# Charlotte Department of Transportation

## Memorandum

**Subject:** Rezoning Petition 08-053: Located on the south side of West Arrowood Road between I-485 and Whitehall Executive Center Drive

PROPOSED PRIVATE STREET (D)  
B - B' Cross-Section

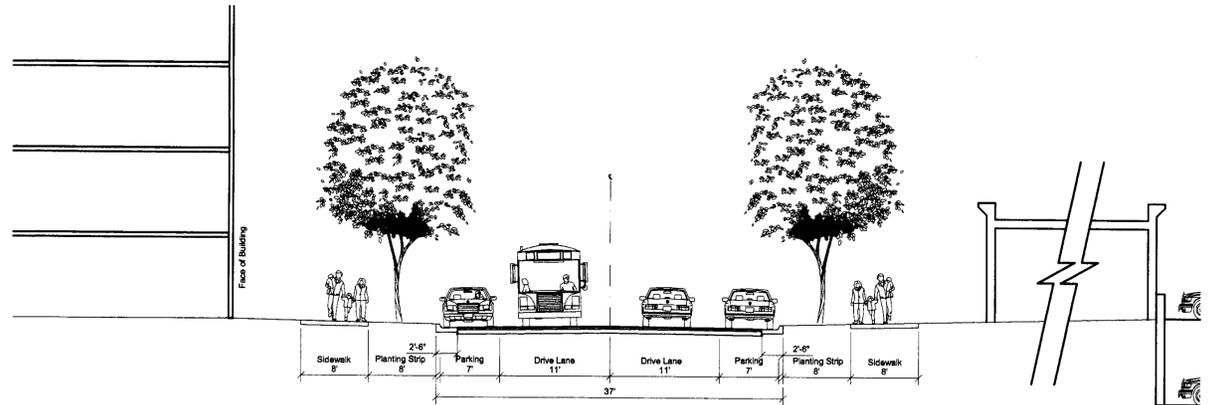
3. The western half of Road E needs be constructed across Moody Lake to connect to Moody Lake Drive as part of the initial site development.
4. The entirety of Roads A, B, and D, and the eastern half of Road E (the part southeast of Road A), need to be public streets.

5. Two streets (which can be public or private) need to connect Road A and Road C, on each side of Parcel 3.
6. Direct driveway access from the retail outparcels to Roads A and D will not be supported. These accesses need to be obtained from Road B exclusively.

PROPOSED PRIVATE STREET (E)  
E - E' Cross-Section

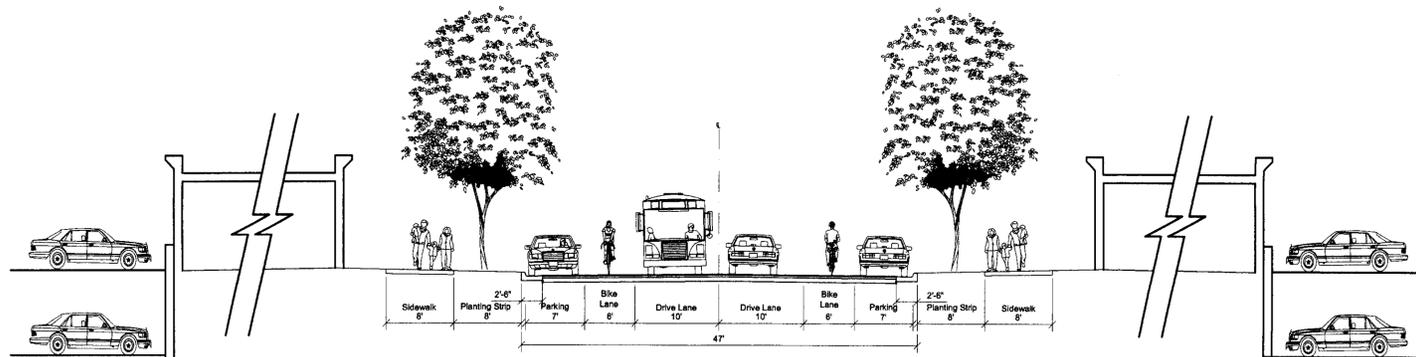
7. Bike lanes need to be provided on all internal public streets and on the private street portion of Road E. Bike lanes also need to be provided on any widened portion(s) of Arrowood Road in both directions.

ARROWOOD ROAD  
F - F' Cross-Section

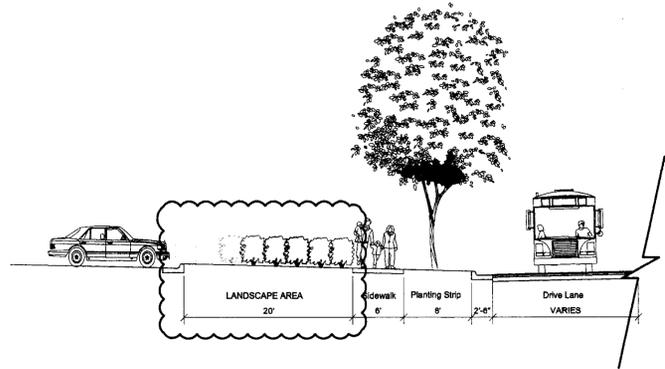
9. Given the intensity of the proposed land uses, the sidewalk along Arrowood Road needs to be increased in width to 8 feet instead of the minimum 6-foot width required by MUDD.
